29 June 2017

File Number: SSD 8351
Our Ref: R/2017/8/A

**RE: Concept Proposal for the Development over Martin Place Metro Station
(SSD 8351)**

View from the centre of Castlereagh Street south of Martin Place looking north

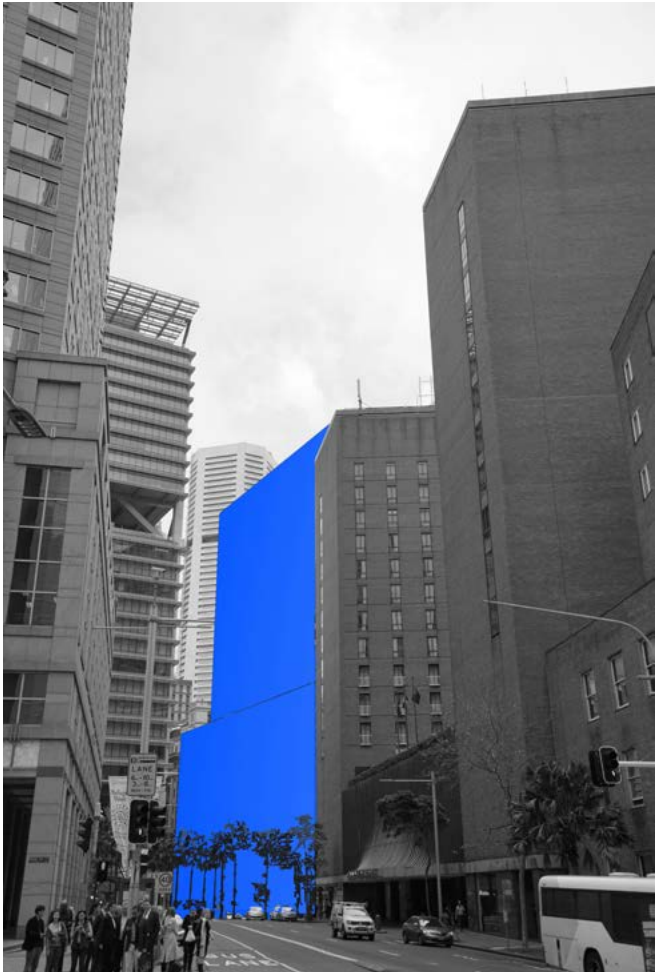
The City has provided within **Attachment B**, a view analysis of the existing site; which includes:

- A complying form and FSR proposal;
- A complying form proposal (this building could include voids); and
- The proposal, which is non-complying.

This analysis clearly indicates the detrimental impact the proposal will have on the streetscape due to lack of setbacks. This is due to its unrelieved bulk, scale, height and form and will result in reduced daylight to City streets.
